## **Planning Act 2008 (as amended) – Section 51**

### **Application by RWE Renewables UK Dogger Bank South (West) Limited and RWE Renewables UK Dogger Bank South (East) Limited for an Order Granting Development Consent for the Dogger Bank South Offshore Wind Farms**

#### **Advice following issue of decision to accept the application for examination**

-  Offshore Order Limits
-  Marine Conservation Zone (MCZ)
-  Special Protection Area (SPA)

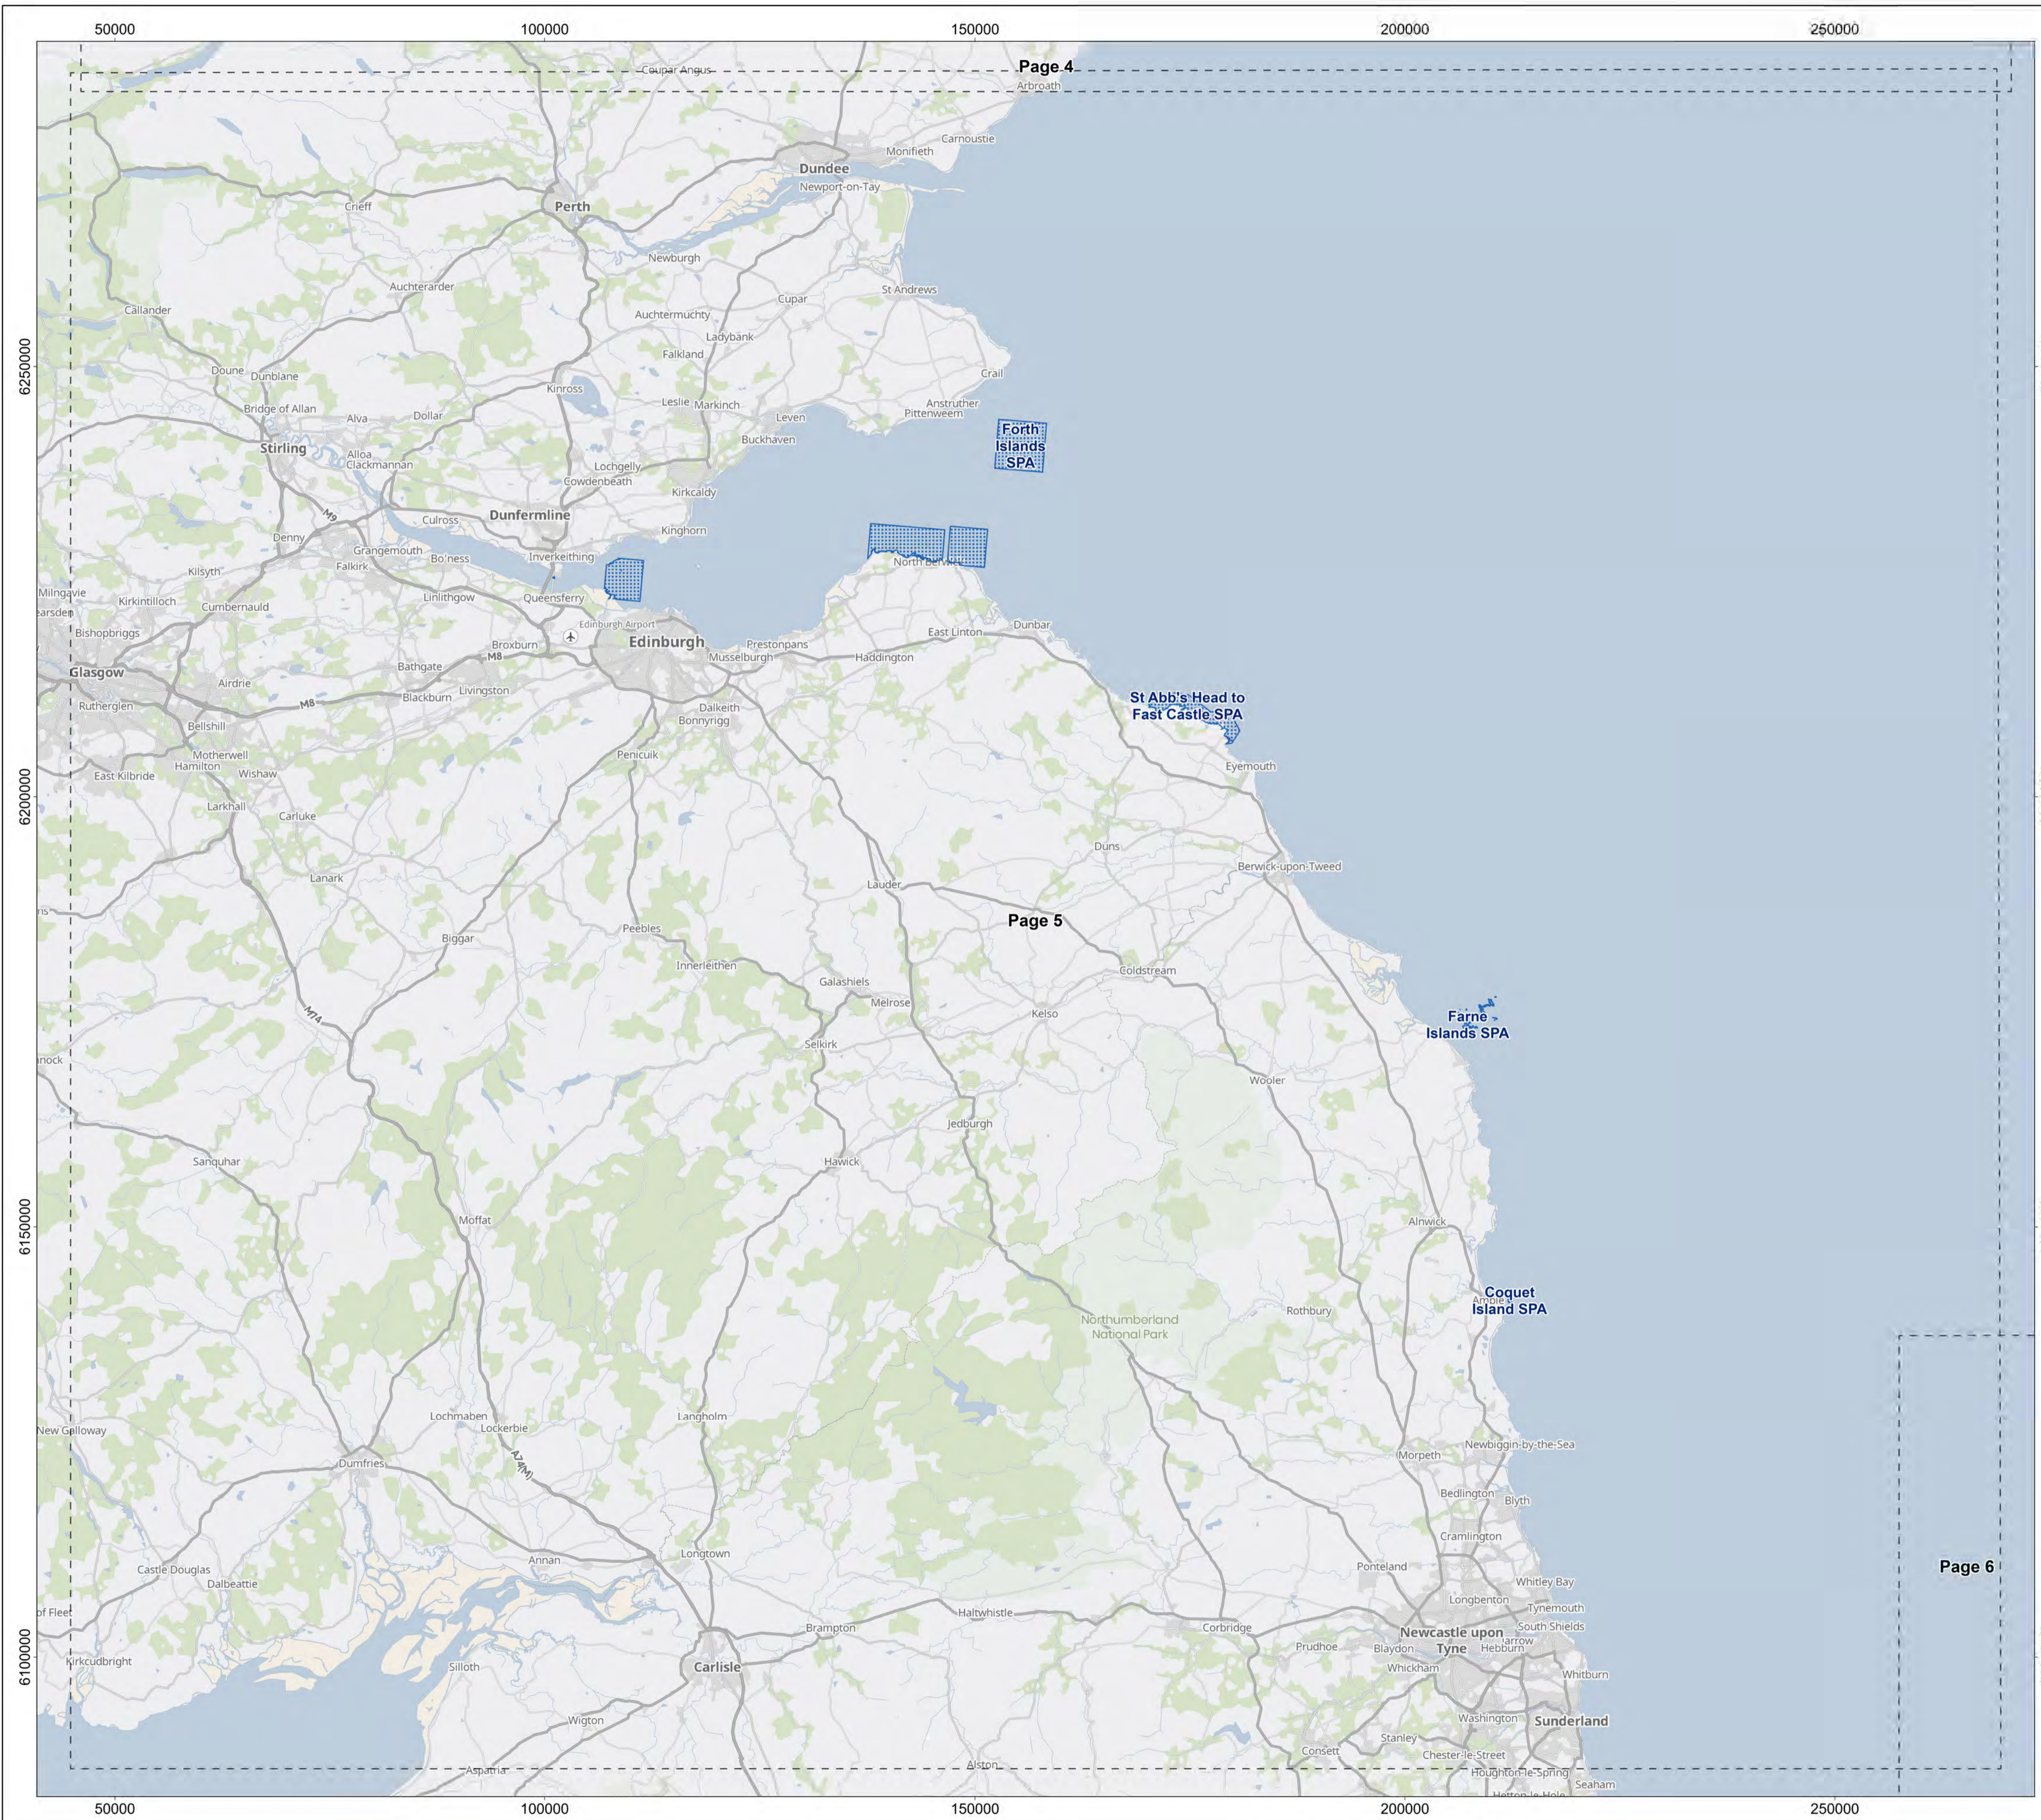
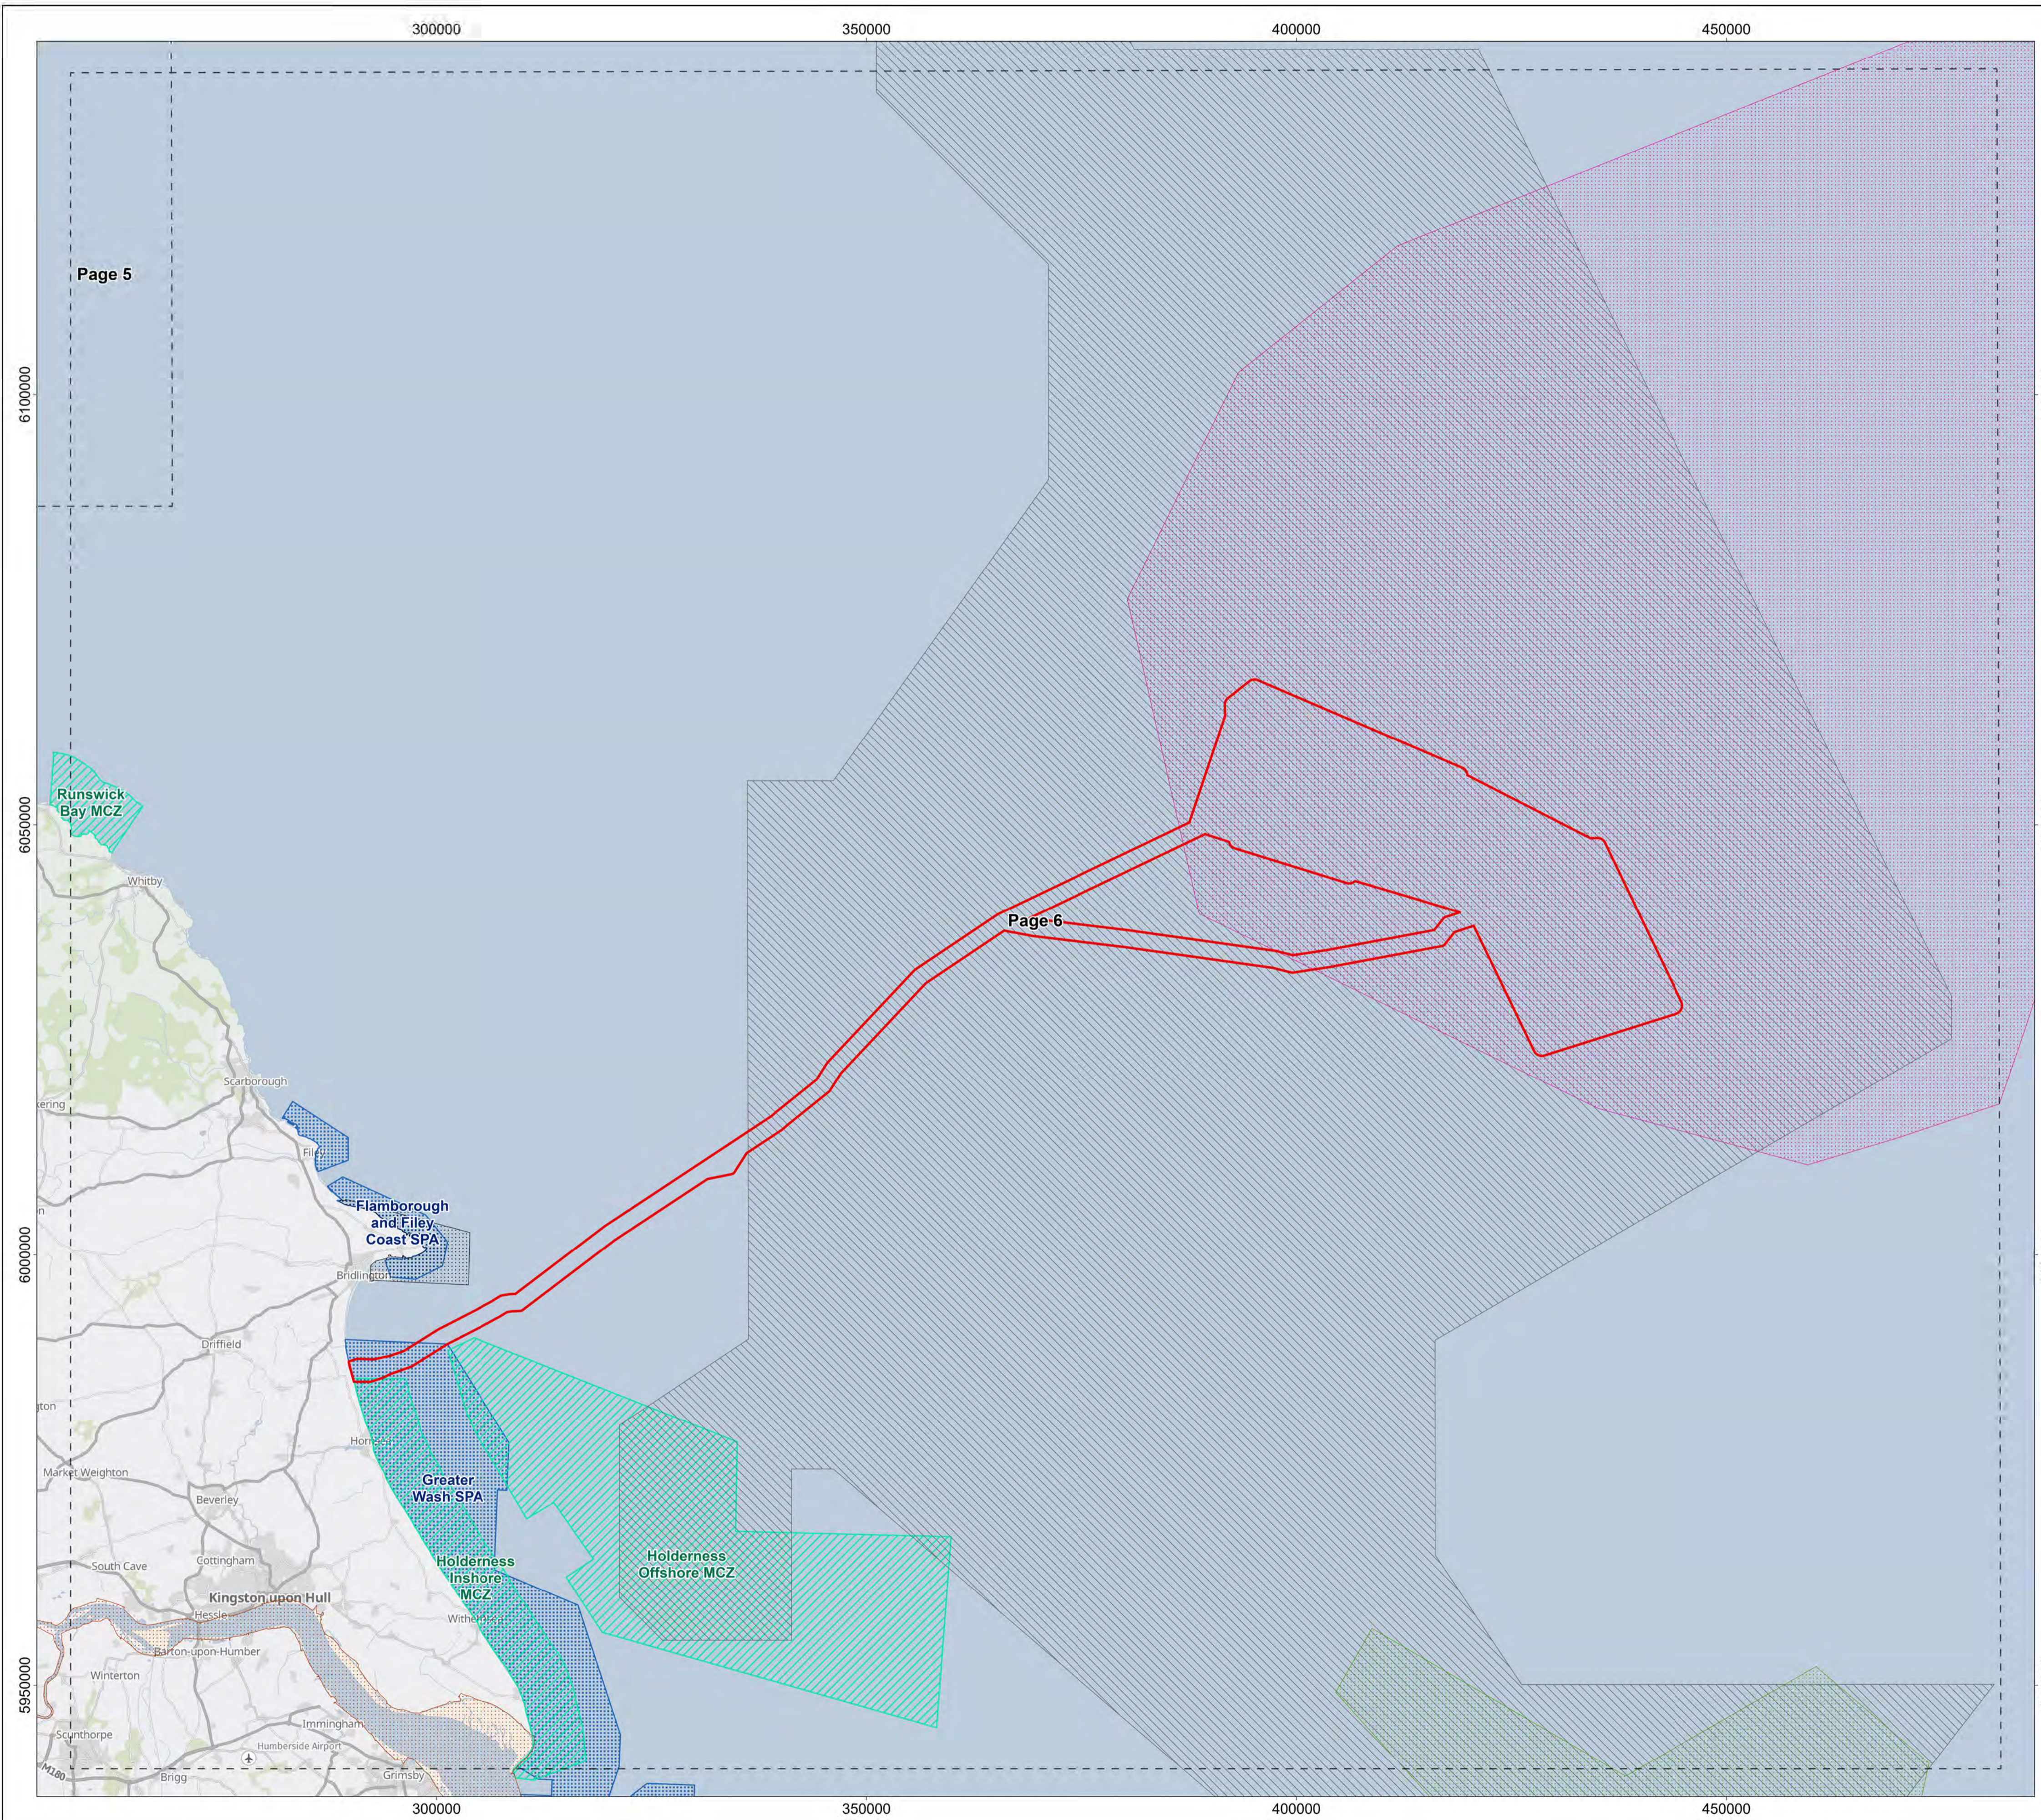
The **Offshore Statutory and Non-Statutory Nature Conservation Sites Plan (Doc 2.13)** identifies the relevant sites considered in **ES Chapter 12 (Offshore Ornithology) (Doc 7.12)** and **Report to Inform Appropriate Assessment (RIAA) (Doc 6.1)**, with the exception of Special Protection Areas (SPAs) beyond 10km from the Proposed Development (eg Farne Islands SPA or SPAs in Scotland). The Applicant is requested to provide plans/figures to illustrate the locations of these SPAs.
